From: lesley lund <lesleylnd@gmail.com>
Sent: 10 July 2015 06:39
To: planning
Subject: 3/2015/0247 - Thorn Cottage Knowsley Road Wilpshire

Drawing Title
Existing Site Plan

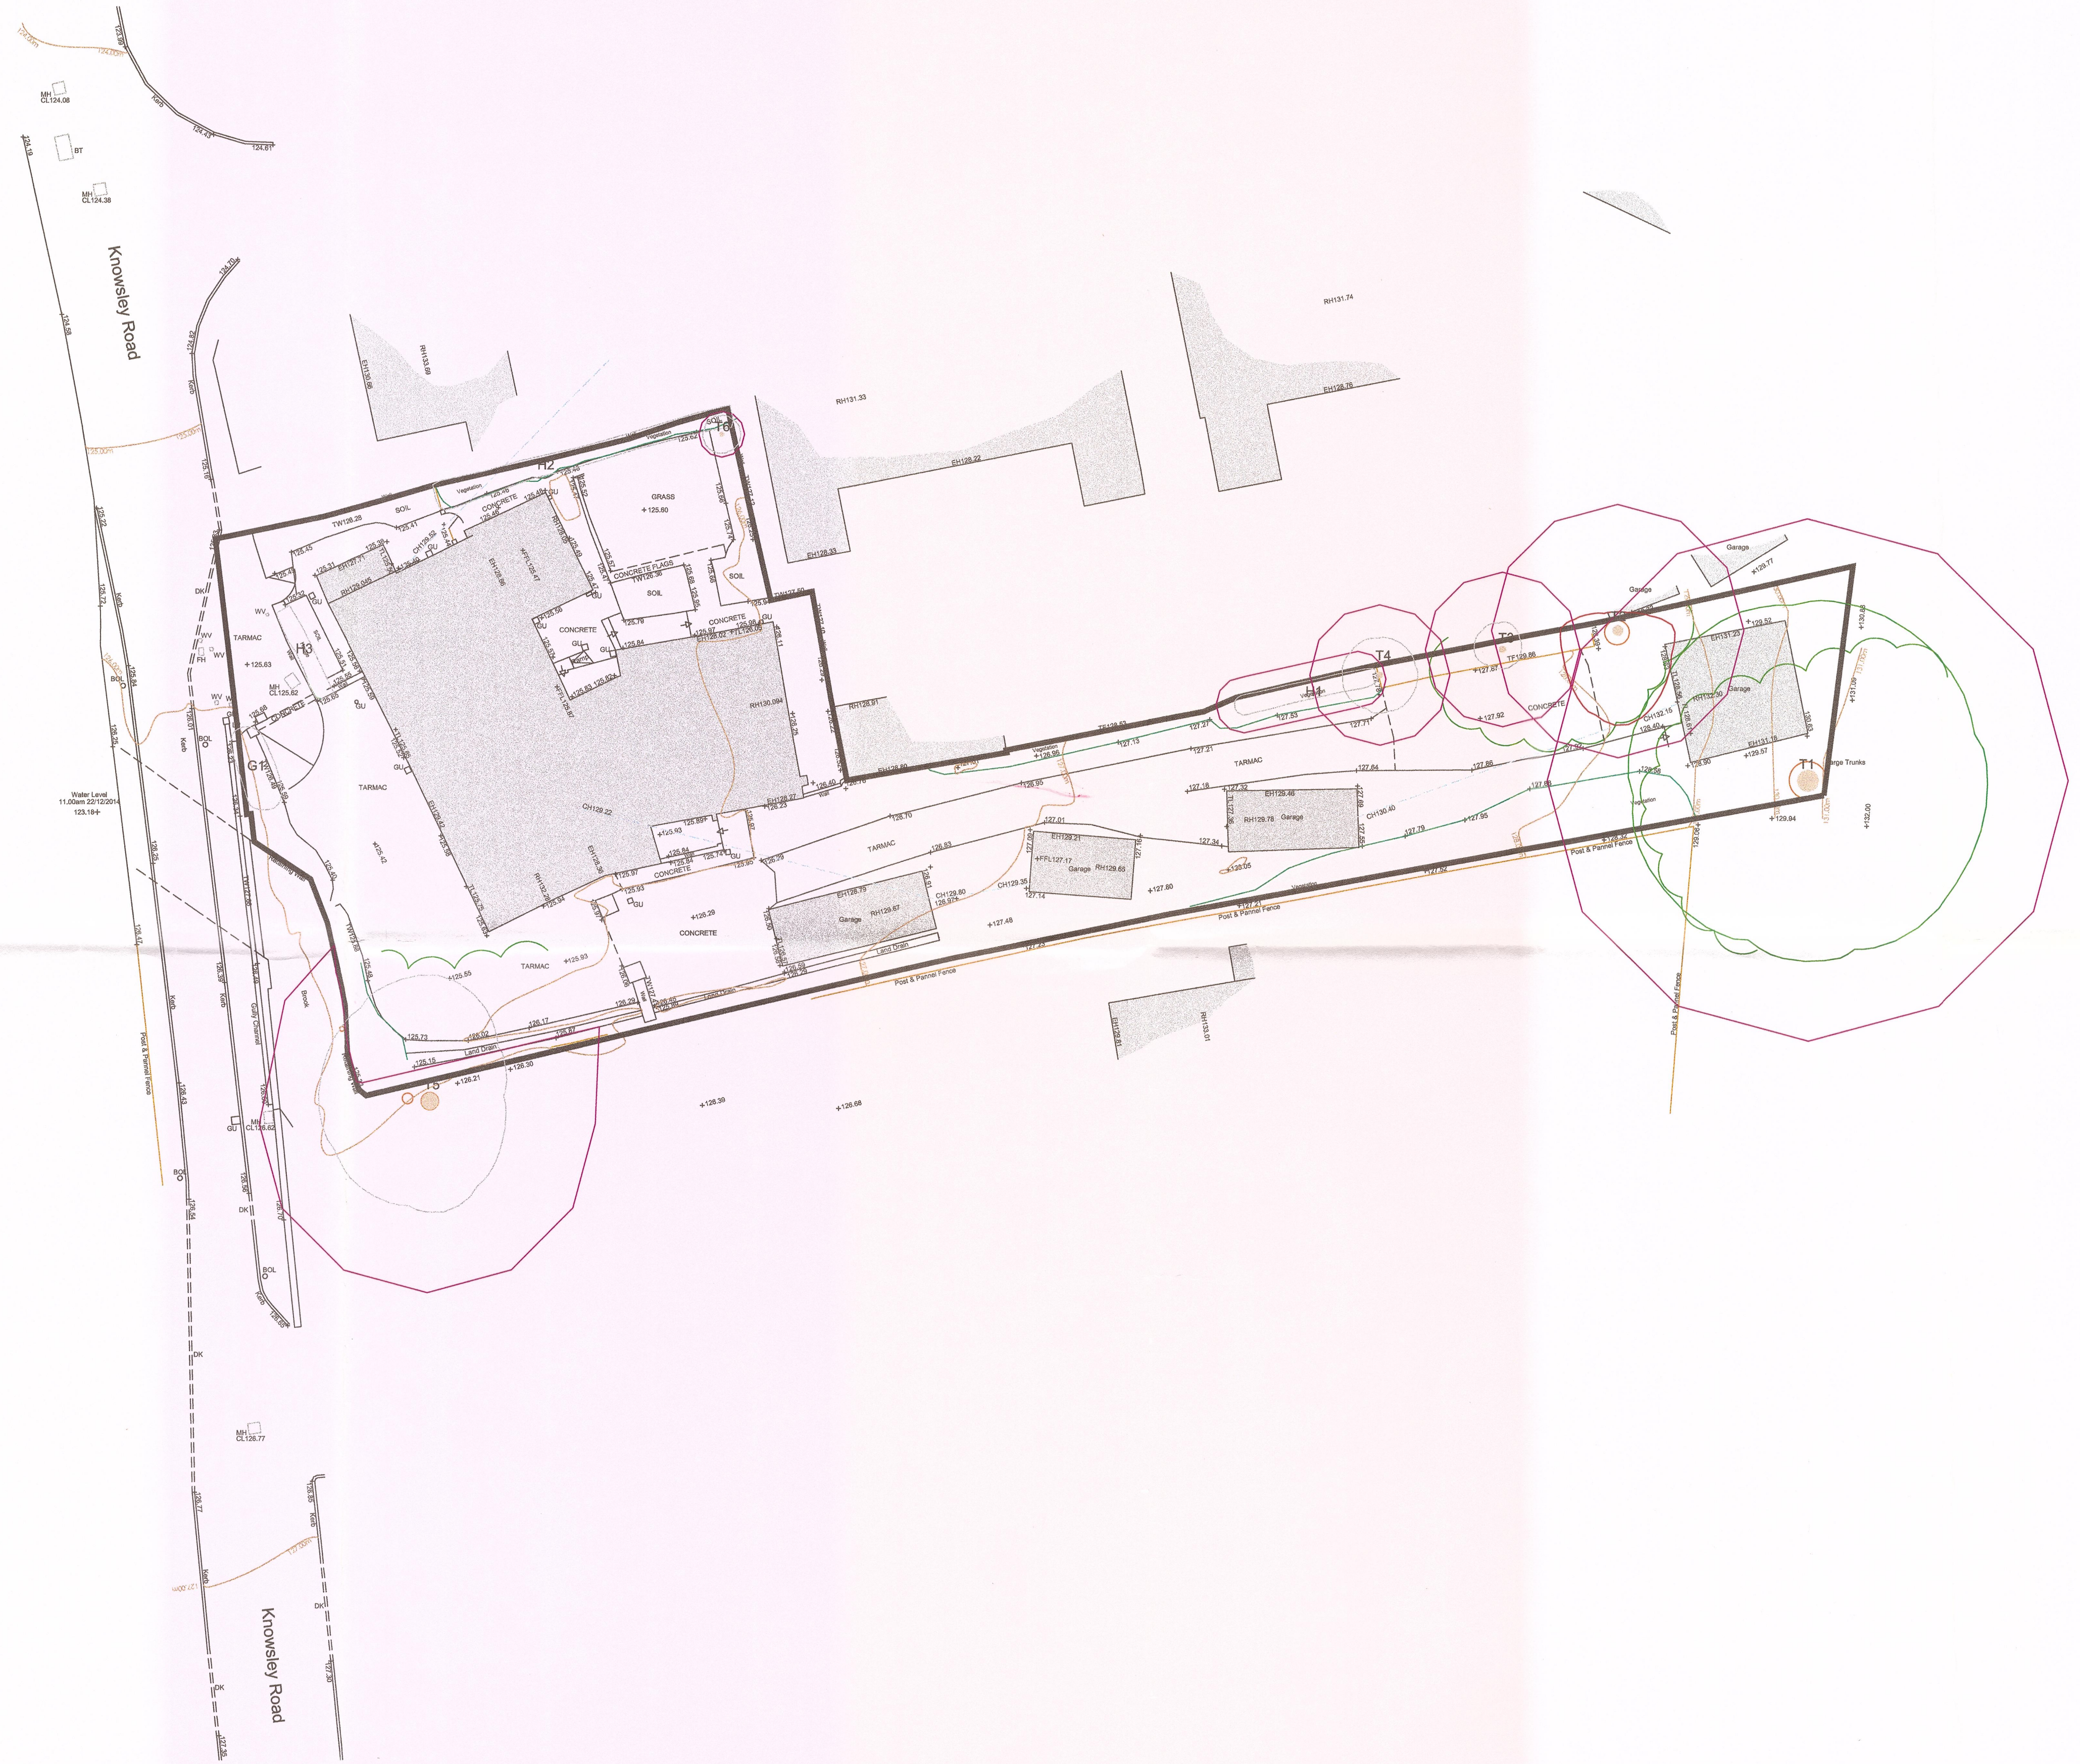
The Council would like to draw to the officer's attention the issue of access/egress issues which is very tight and not suitable for 3 properties and also there it is believed that there is Japanese knotweed on the site .
